PORTLAND MAINE

July 29, 2011

CBL: 032 F014001
Located at 1 EXCHANGE ST

NOTICE OF VIOLATION

8/24/10 - per Joe & PJ
 This is the plan to approve submitted as supplement by George N.

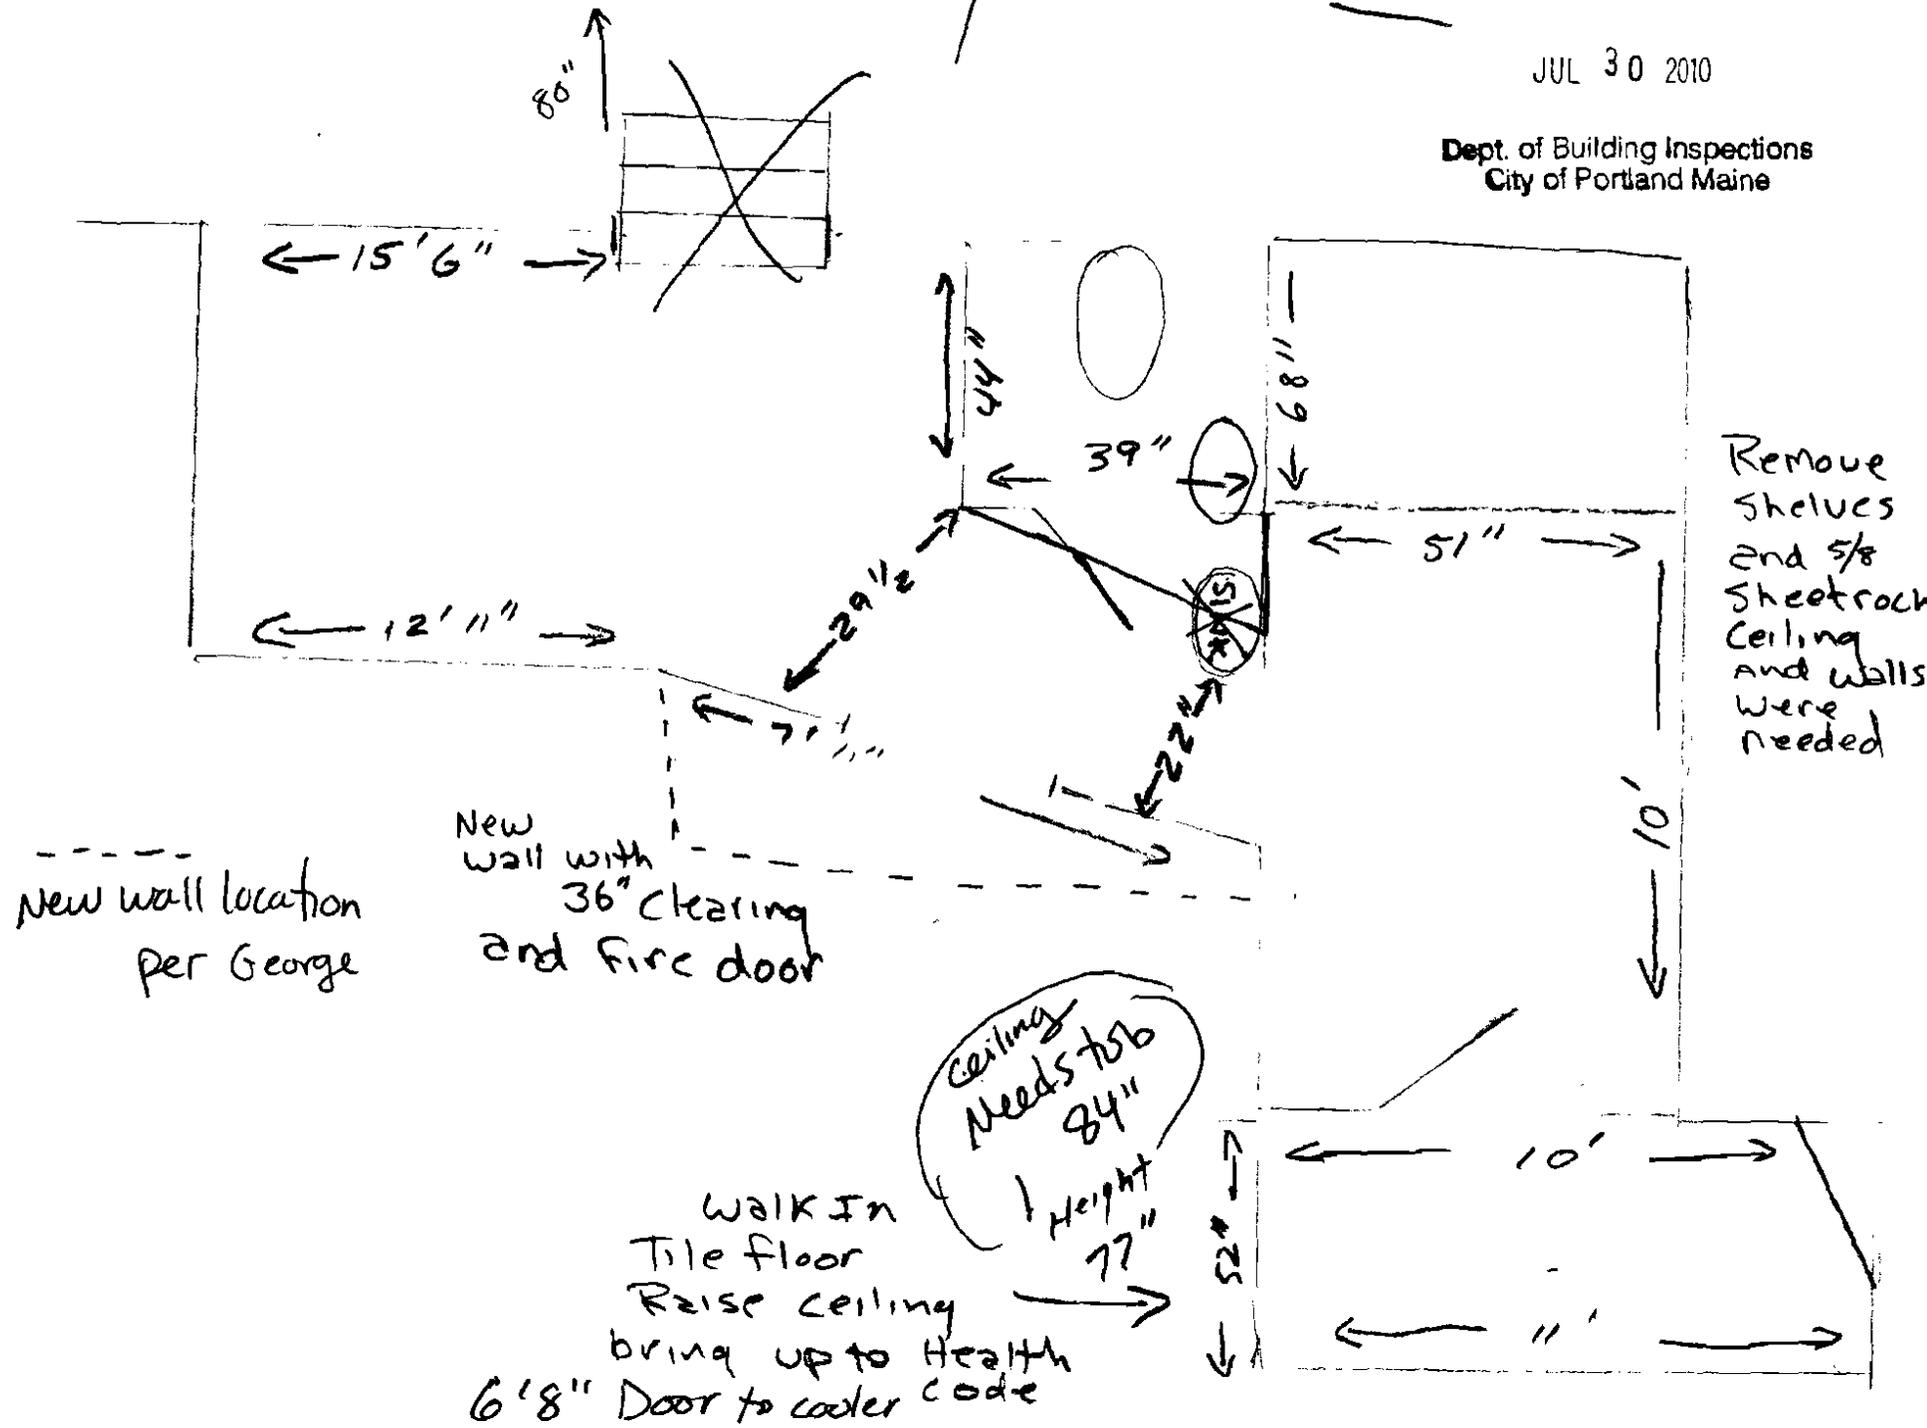
The deviation is that the fire door in the wall leading to the bathroom facility from the retail store, City Beverage, has been removed, and replaced with studs and drywall, thus closing off the access to this bathroom. A bathroom is required on the premises of the retail business and cannot be eliminated as a result of the change of use at 7 Exchange St.; The Exchange St. Cafe. The removal of the existing bathroom for the employees of City Beverage is in violation of Section 11-22 of the Food Code and Section 412.3 of the Plumbing code of the City of Portland. See the attached code sections.

This is a notice of violation pursuant to Section 6-21 of the Building Code for deviation from an approved building permit. You have 15 days to apply for a permit for the changes made, and to comply with bathroom requirements for City Beverage. Any new work shall not commence until an application for permit is submitted and approved. Any existing bathroom facility is subject to inspection for approval prior to use.
